**IP NUMBER [REDACTED]: FOSSE GREEN DEADLINE 6 COMMENTS**

This document is in three sections; Section A provides comment on the Applicant's Response to Deadline 5 Submissions (Revision 1), Section B provides comment on the Applicant's Response to the Examining Authority's Third Written Questions, and Section C comments on the Unplanned Emissions Assessment.

Noise Contours - Operational Phase
Distributed BESS

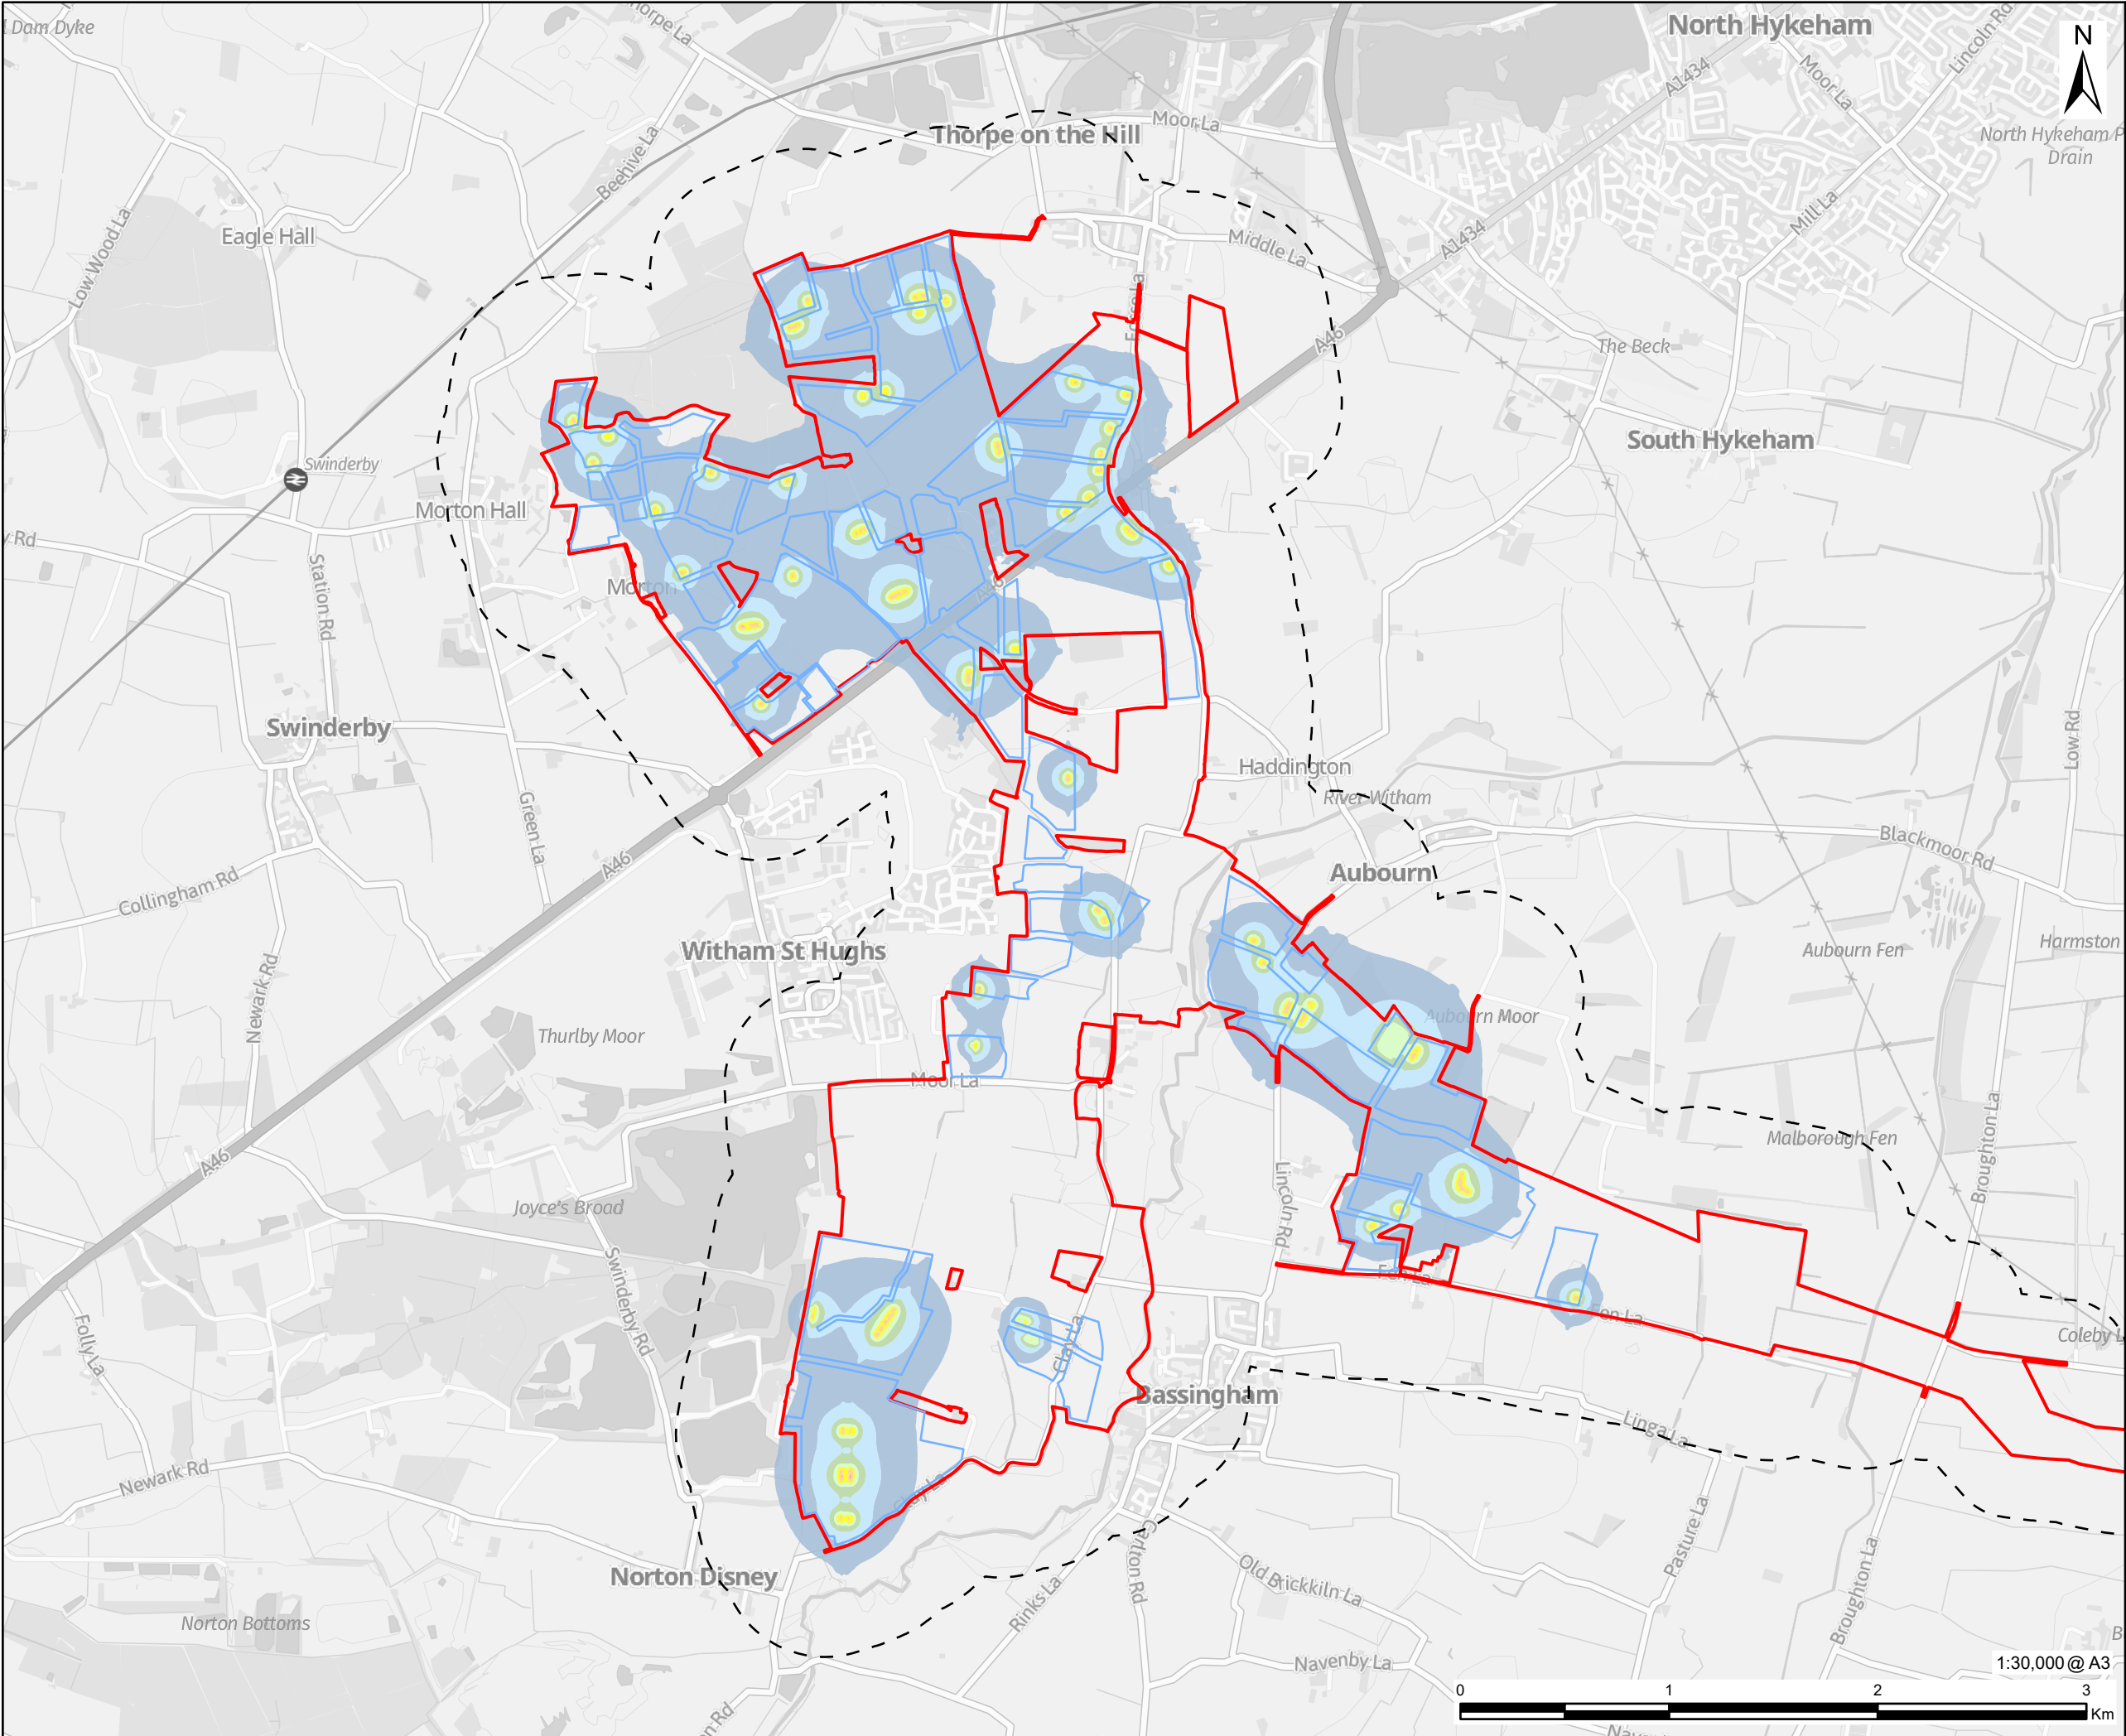
A.13 At Paragraph 11.4.18 of APP-036 the Applicant states “..... given the linear nature of PRoWs and Permissive Paths, the range of noise impacts along them that forms the ambient noise environment, and the transient usage of a PRoW or Permissive Path, a material change

*in the experience of using the PRow or Permissive Path as a whole as a result of noise emissions from the Proposed Development, which could affect PRow and Permissive Path user's health or quality of life, is not anticipated."* Firstly, one of the most popular walks in the area is a circular walk commencing and finishing in Thorpe on the Hill which if the proposed development is approved, will be subject to continuous noise from the proposed development as this circular route is traversed. Secondly, given the Applicant states PRow have been scoped out as noise receptors, how can the Applicant come to such a conclusion in the absence of any noise impact assessment.
